**From:** Carol Marra  
**Sent:** Tuesday, 1 December 2020 5:05 PM  
**To:** Candice Pon  
**Subject:** MAAS Castle Hill Expansion of the Museums Discovery Centre (SSD-10472)

I have reviewed the EIS document for this SSD and have the following comments:

Building J | Landscape Plan

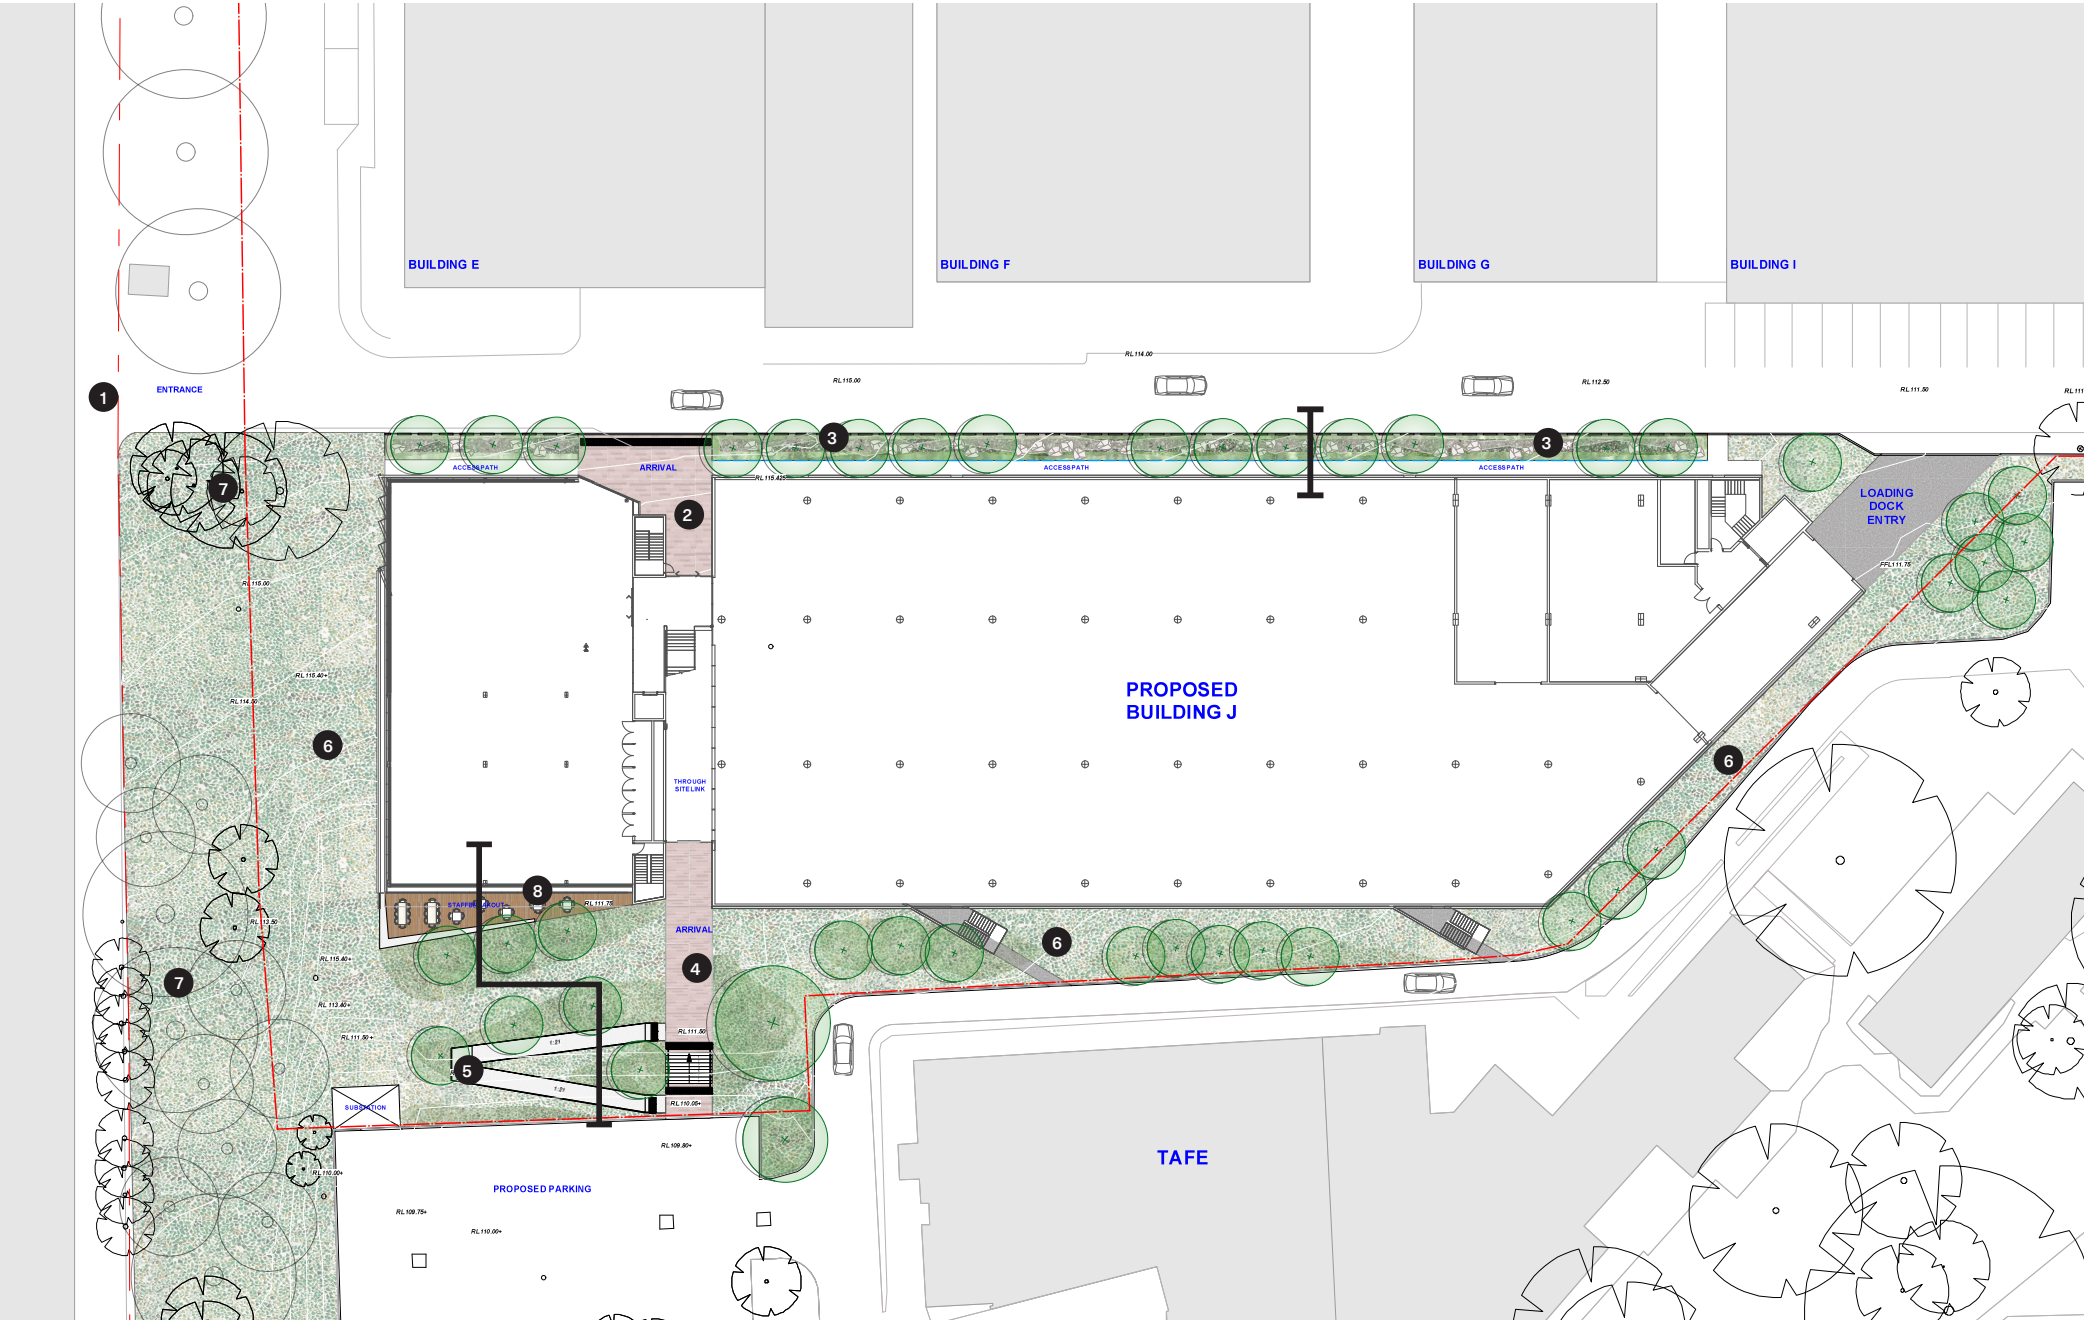
- The documents note a tree-replacement strategy is to be implemented. Clarification is sought on the proposed locations for tree planting and whether any additional tree canopy cover will be incorporated on the subject site, for example in the 'bushland edge' along Showground and Windsor Rds

- The inclusion of additional shading, either through planting or structures, for the entry square requires further consideration in response to the microclimate of the site.

- Clarify management of vehicular traffic. Currently both vehicles and pedestrians are shown entering the site at the point the 'entry square' intersects with Showground Rd. Demonstrate how will pedestrians be prioritised in the 'entry square' on weekends and other open-to-the-public days.

Eastern Arrival

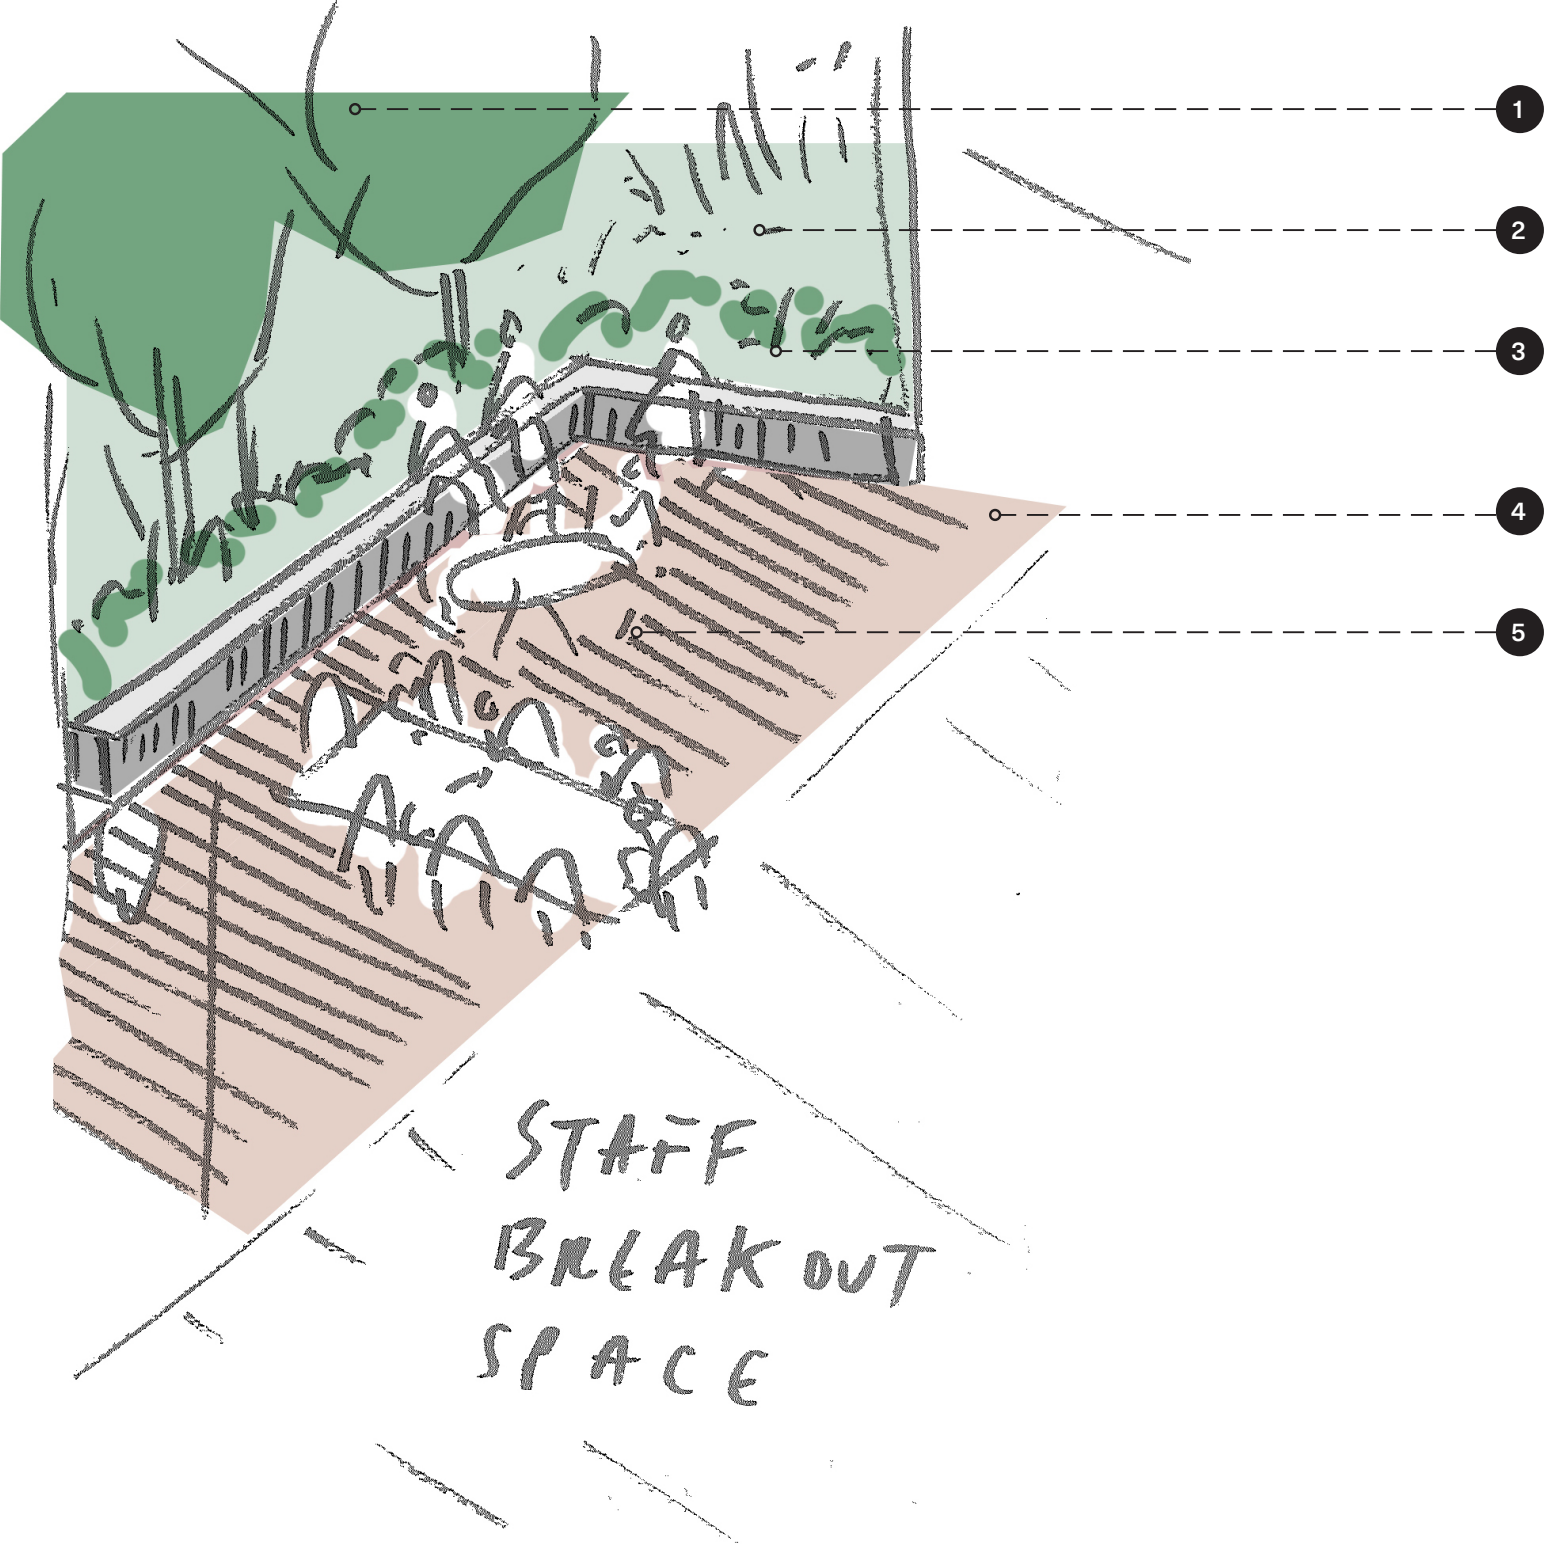
- Clarification is sought on the need for the creation of additional carparking area and tree removal on the eastern edge of the site. Could existing carparking areas on the TAFE site be used so that tree removal can be minimised.
